PLANNING (LISTED BUILDING AND CONSERVATION AREAS) ACT 1990

LISTED BUILDING

Reference:	H16-0645-22	Date of Decision:	11th November 2022
Applicant:	Mr S Sadiq 19 Park Crescent Peterborough PE1 4DX		
Location:	The Grange 8 Pinchbeck Road Spalding		
Description:	Proposed change of use from vacant offices to HMO including erection of cycle/bin storage

DRAWING
Proposed Ground Floor
Plan

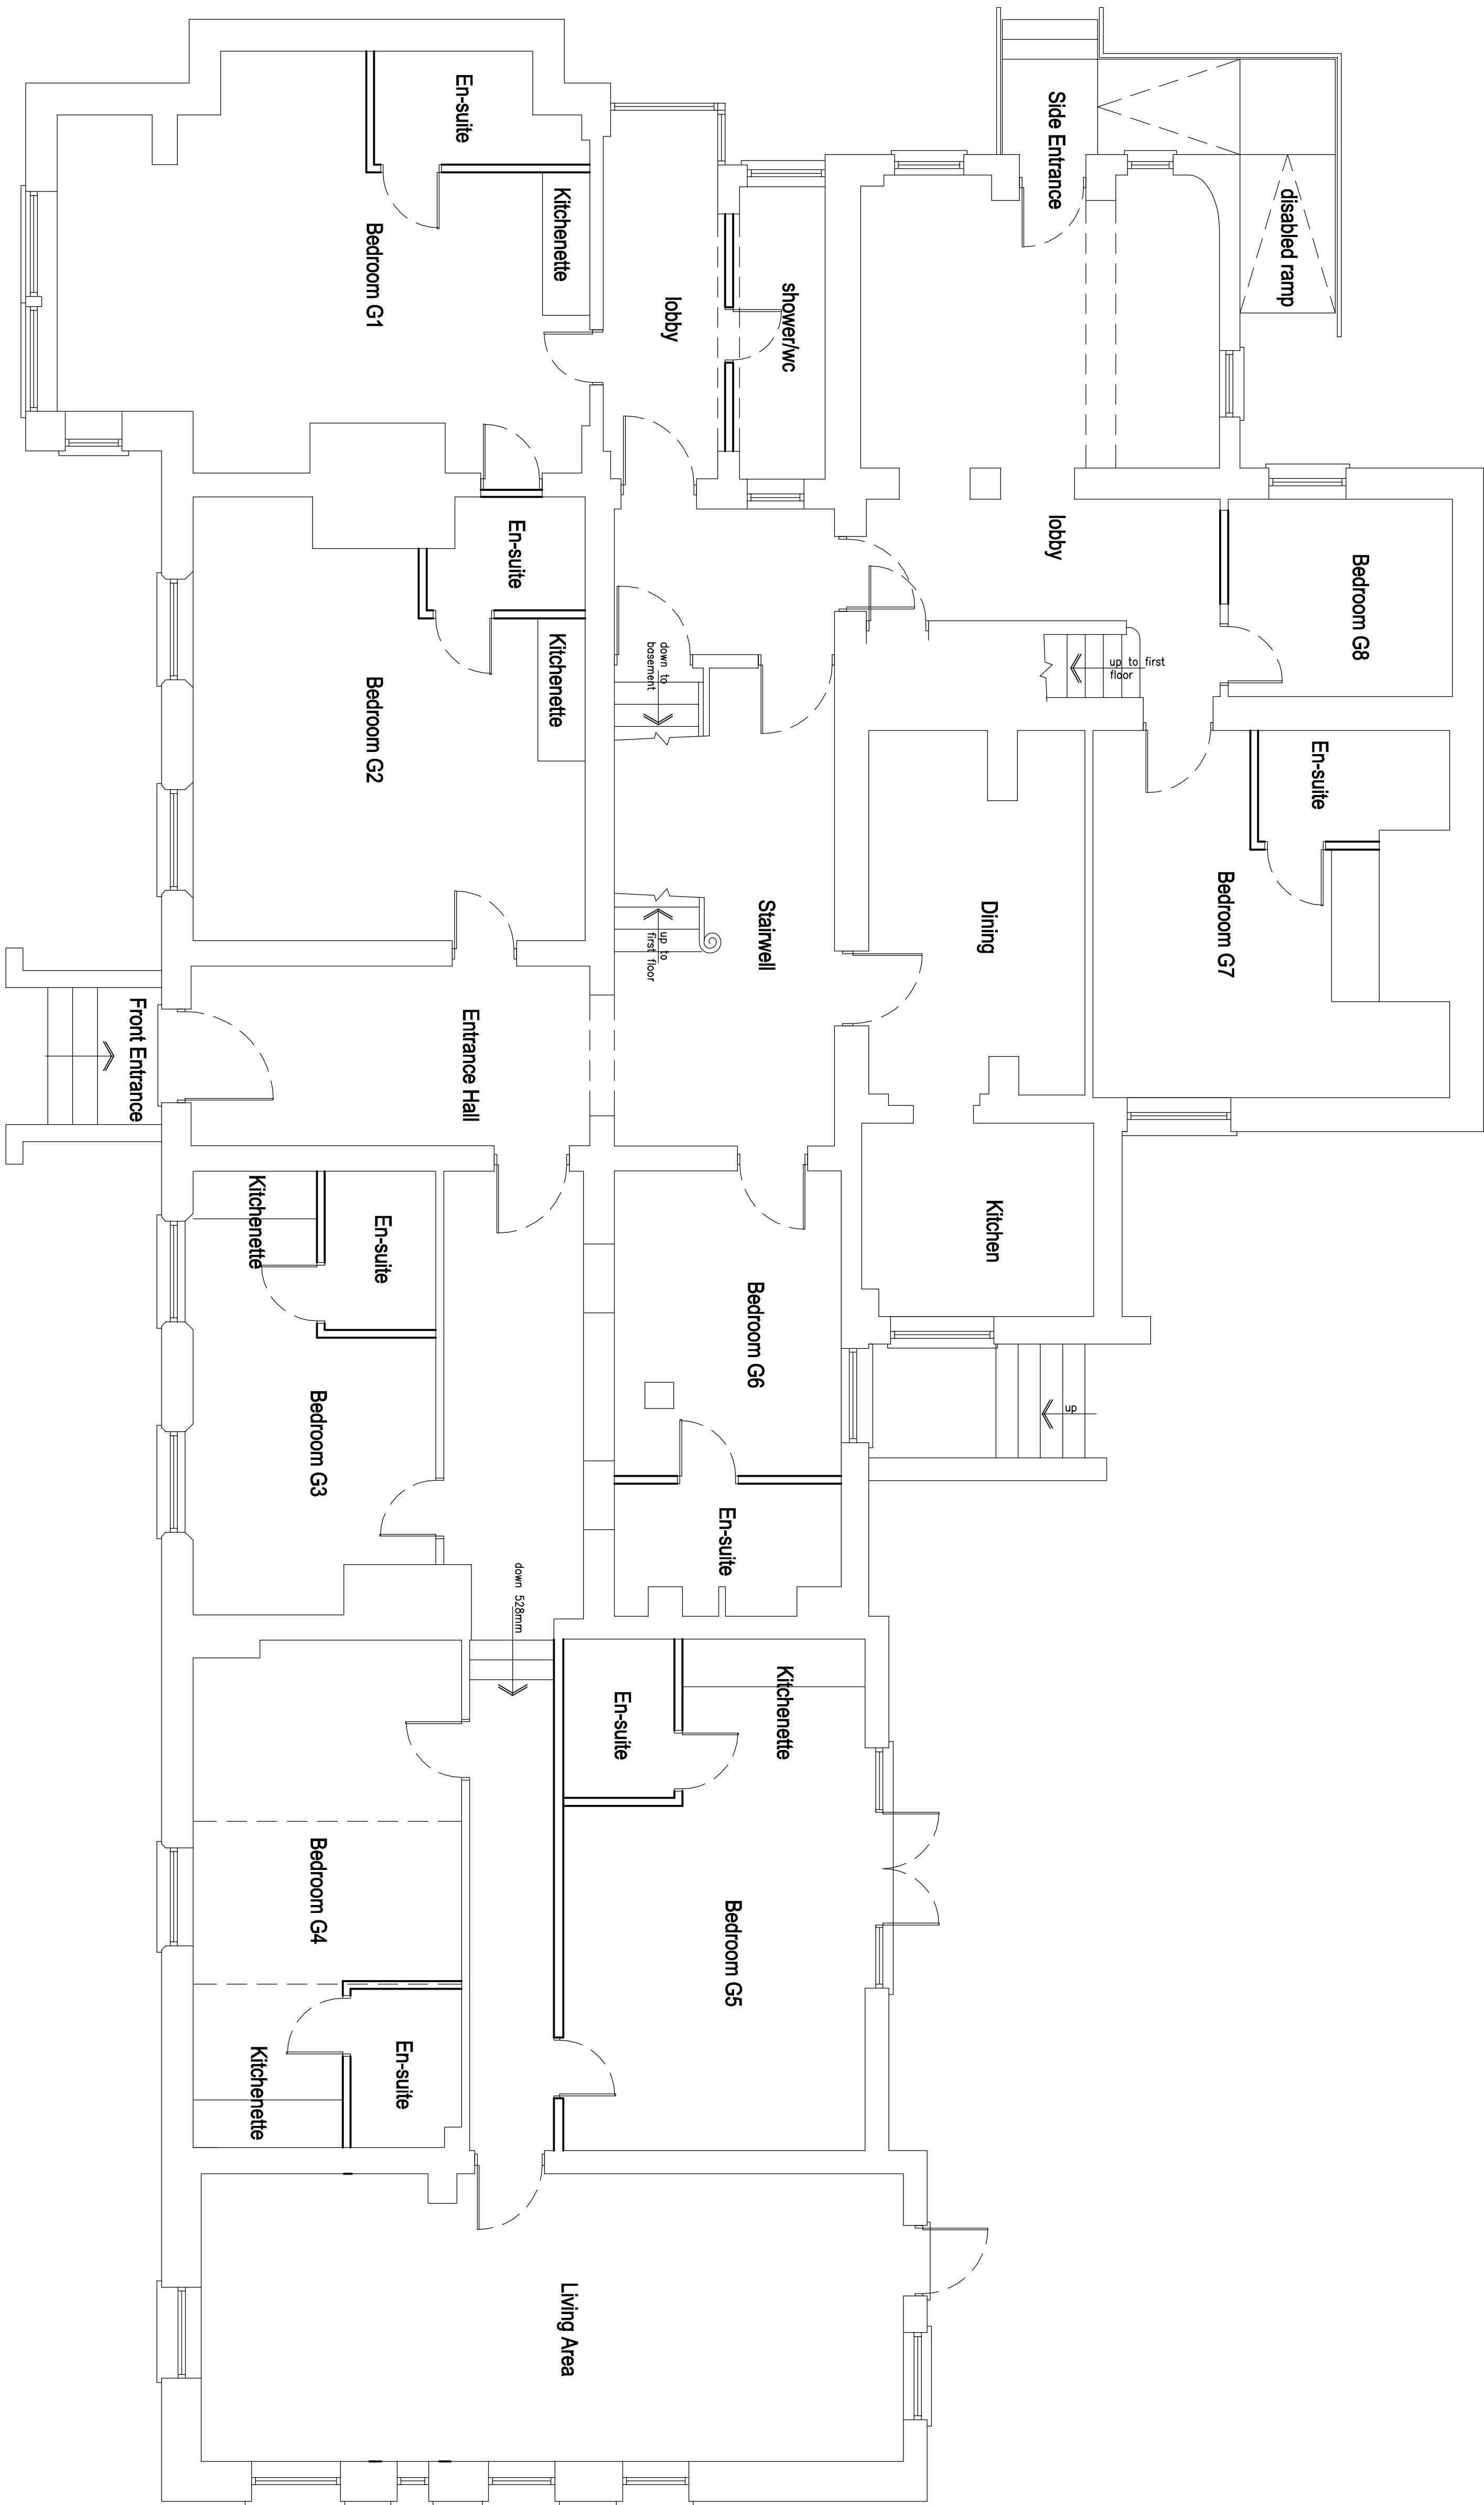
- 1 As a grade II* listed property, the proposed additional and extensive subdivision of the property would lead to a substantially detrimental impact upon the remaining character of this site and would establish a much altered internal layout rendering much of the original floorplan further unreadable, causing a harmful effect upon appreciation of the heritage asset. Therefore, the proposal falls short of the requirements of Policy 29 of the South East Lincolnshire Local Plan (2019) which established under Policy 29, Section A that all proposals affecting listed buildings should only be accepted where the Local Planning Authority is satisfied that the works are in the interest of the listed building's preservation and do not include proposals which are prejudicial to the special architectural or historic interest of the building or its setting. Furthermore, Policy 29, Section A confirms that developments affecting Listed buildings should only be approved where they preserve or better reveal the asset's significance.

- 2 The proposal to largely pave over the rear garden to the Grade II* listed building is deemed to be unacceptable in policy terms. The proposal to create a large, permeable hard-standing area to the rear in the extant garden area would be detrimental to the overall character of the site by substantially harming and degrading of the quantity of open, private amenity space, via the addition of a large, unflattering car park to the rear of this property which currently enjoys and is partly characterised by its large garden. It could be said that such a proposal in isolation would represent less than substantial harm to the site, however, Para 202 of the NPPF (2021) states that where less than substantial harm will be incurred by a proposal it can only be justified through weighing against the public benefit or its contribution toward achieving the site's optimal use. It is not considered that there is substantial enough public benefit presented by this application and neither is a HMO considered to be the optimal use for this site and therefore, the inclusion of such a large alteration to the garden space does not assist in achieving an optimal use in any way. In this instance, it is clear from the history of the site and the numerous instances of pre-application advice that have been issued relating to this site that use as a single residential dwelling or minor subdivision into a small number of large apartments is considered far more optimal. Therefore, the proposal falls short of the requirements of Policy 29 of the South East Lincolnshire Local Plan (2019) which established under Policy 29, Section A that all proposals affecting listed buildings should only be accepted where the Local Planning Authority is satisfied that the works are in the interest of the listed building's preservation and do not include proposals which are prejudicial to the special architectural or historic interest of the building or its setting. Furthermore, Policy 29, Section A confirms that developments affecting Listed buildings should only be approved where they preserve or better reveal the asset's significance.
